DRB Application No.: 08DRB-70525 Project # 1005130
 Project Name: NORTH ALBUQUERQUE ACRES UNITS 3
 Agent: GUS GRACE, PE/ MICHAEL SMITH PE Phone No.:

CITY OF ALBUQUERQUE
PLANNING DEPARTMENT
December 31, 2008
DRB Comments

**RE: Lots 7-A and 25, Blk. 10, Tr. 2, Unit 3, North Albuquerque
Acres**

**PLAT OF  
 LOT 7-A-1, BLOCK 10  
 BERNALILLO COUNTY,  
 ALBUQUERQUE, NEW MEXICO**

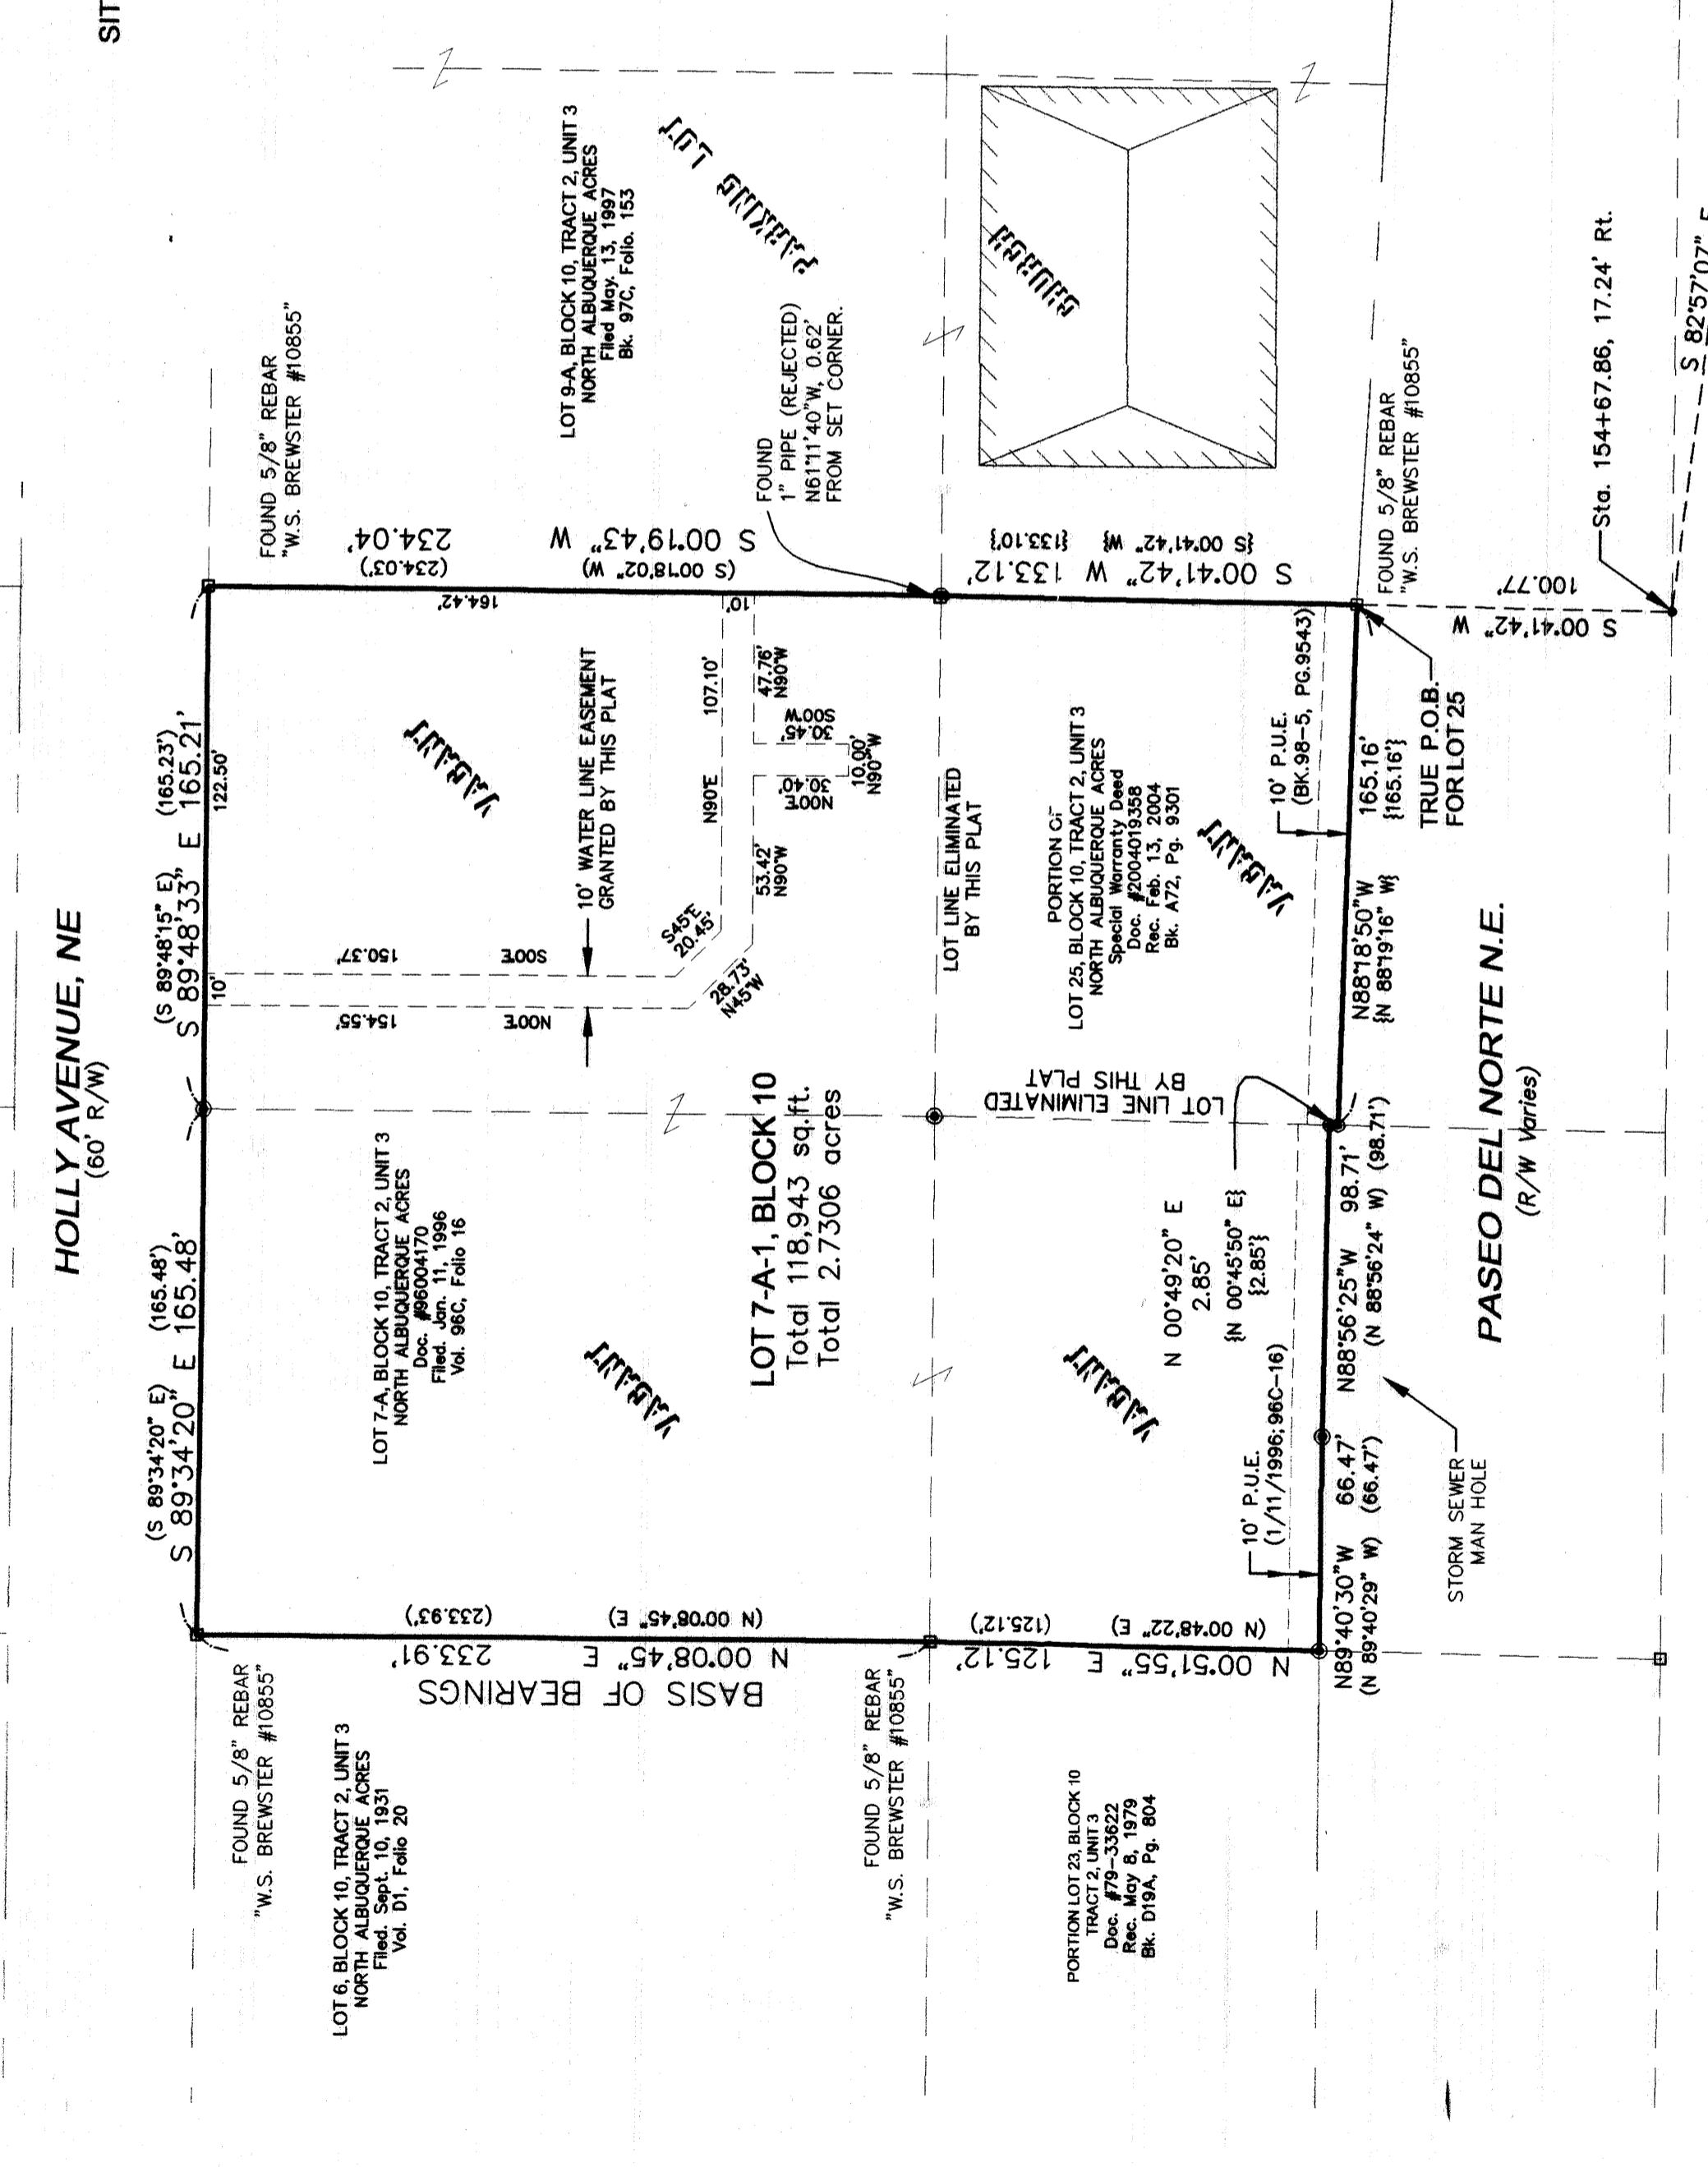
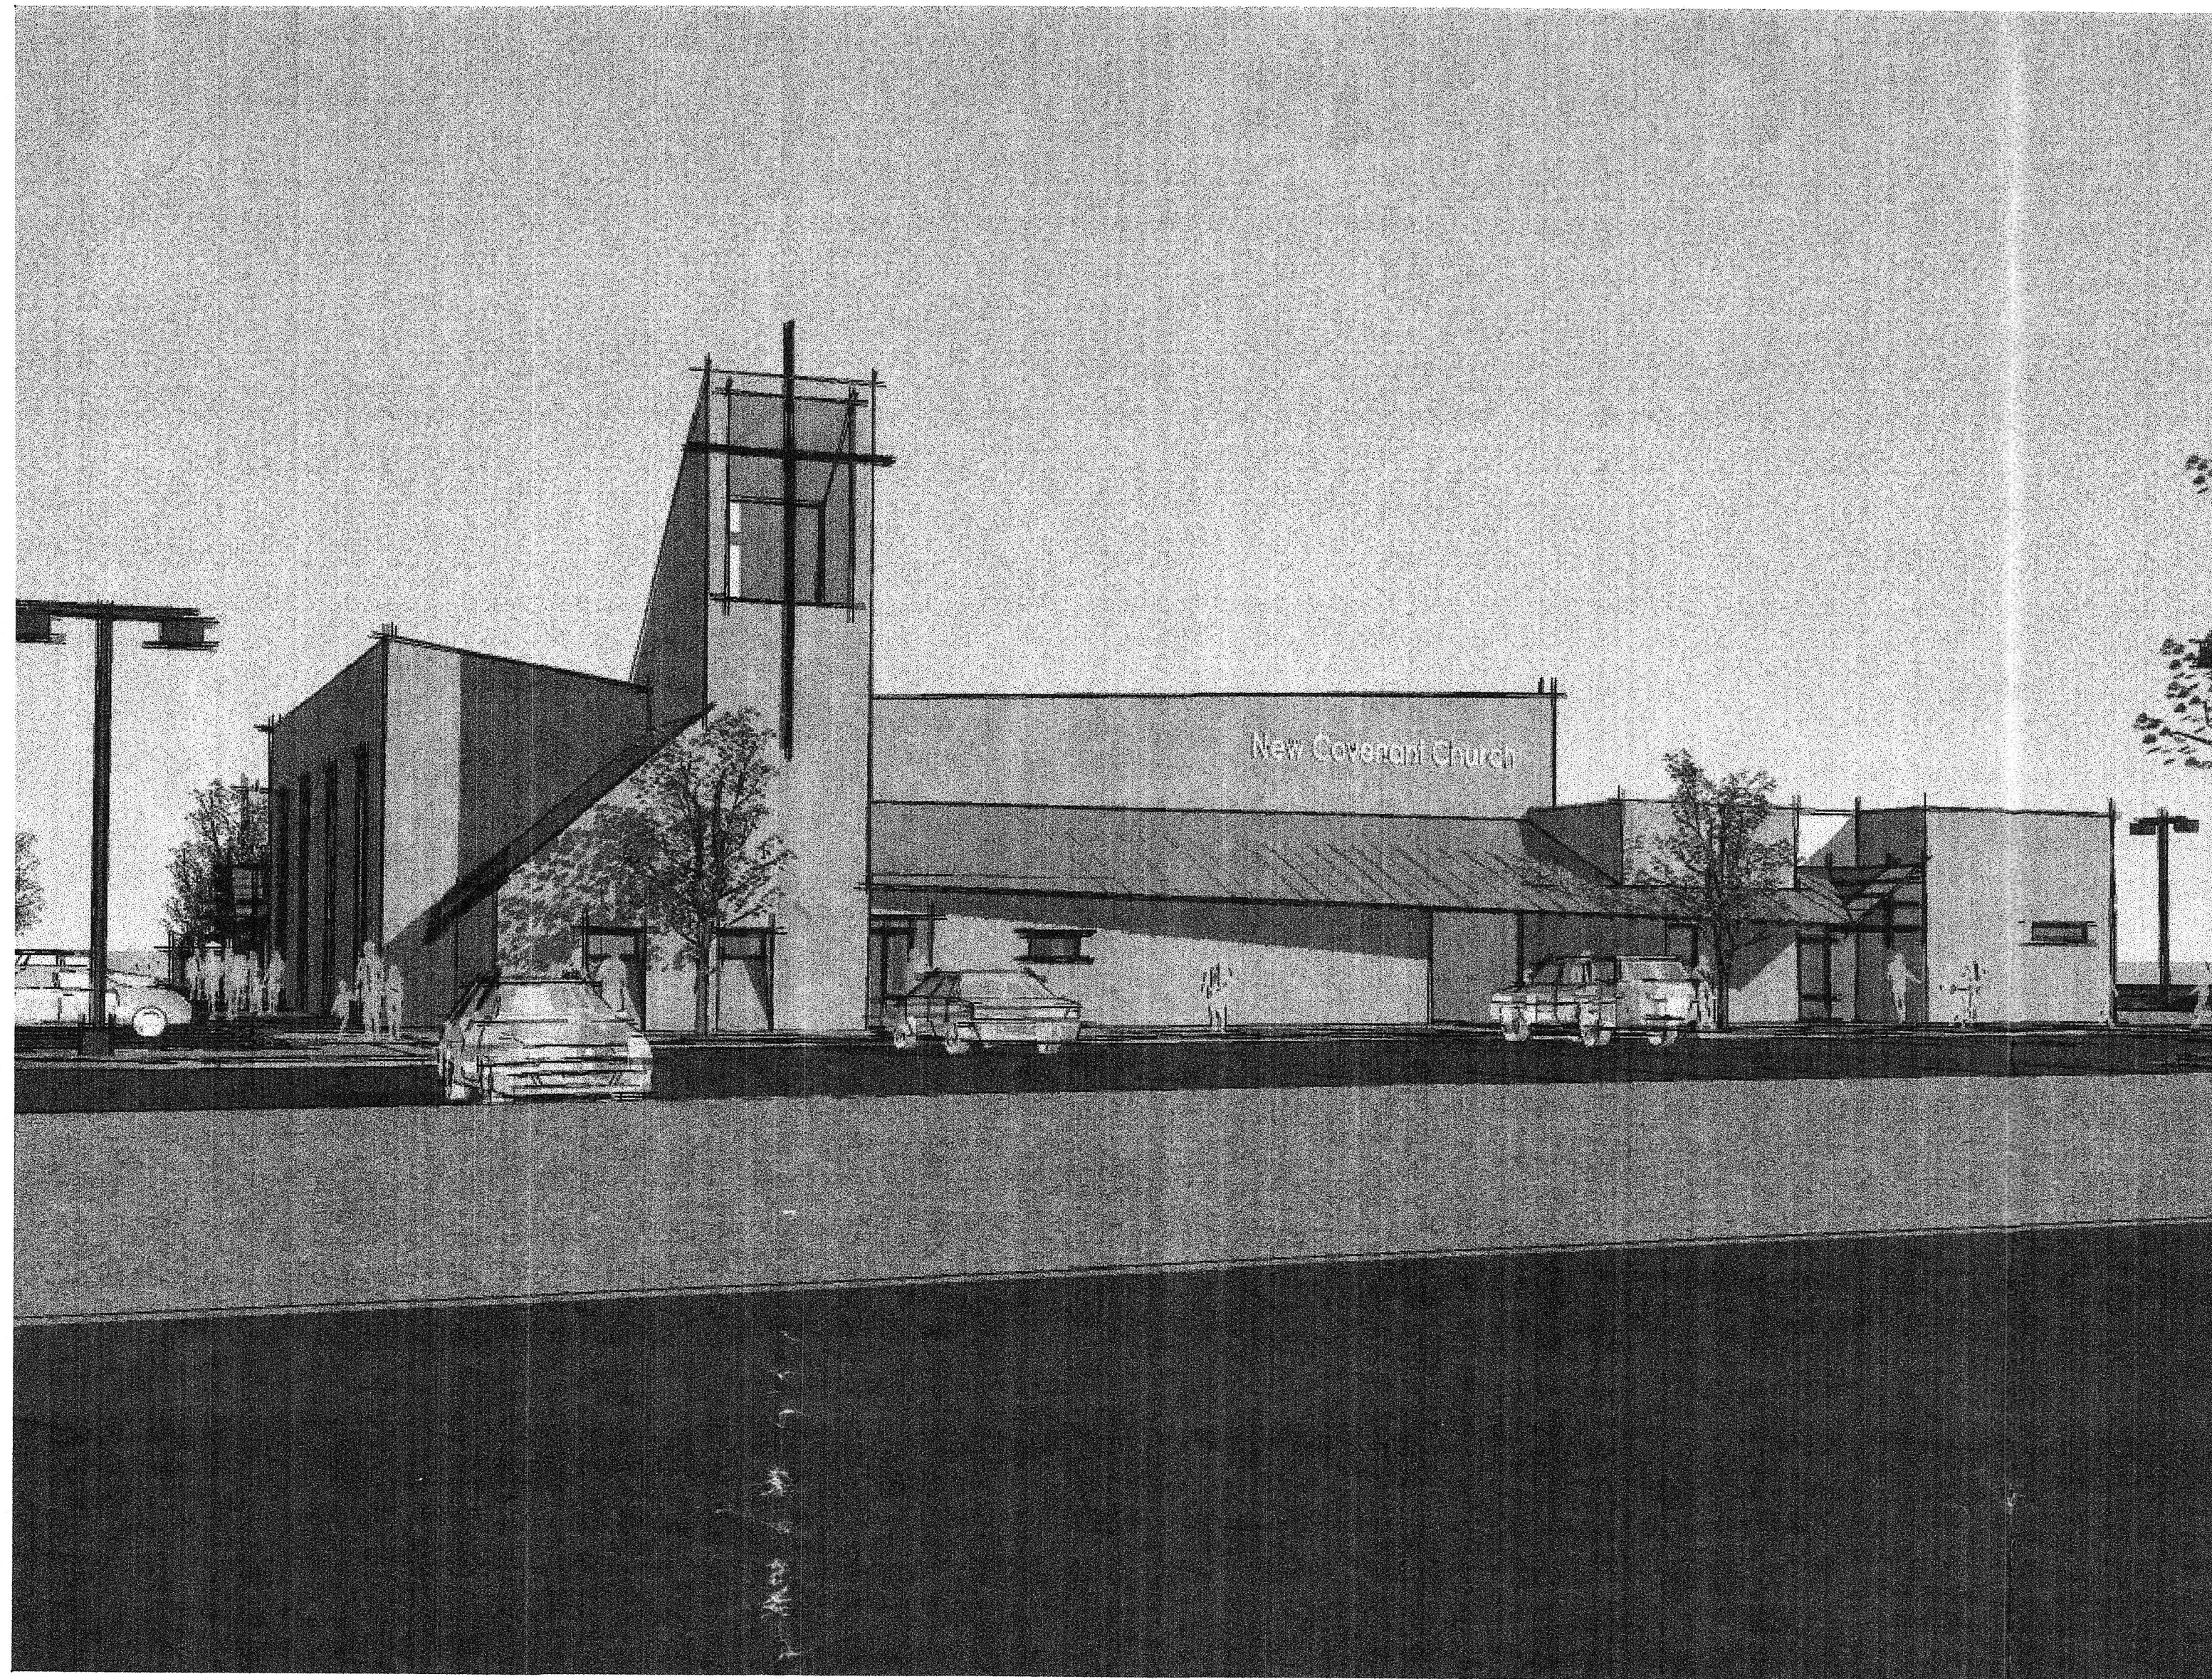
Maintenance and beneficiaries of "Cross-access Easement" needs to be noted on the plat (e.g. "to benefit and be maintained by the owner of Lot 9-A). Water Line Easement needs to be granted to ABCWUA.

A Solar Note needs to be on the plat (consistent with Section 14-14-4-7 of the Subdivision Ordinance) which is specific to this type of request, i.e. use the words "THIS PLAT" (rather than the words "REQUESTED FINAL ACTION") at the beginning of the note, and do not use the words "OR SITE DEVELOPMENT PLAN FOR SUBDIVISION" at the end of the note.
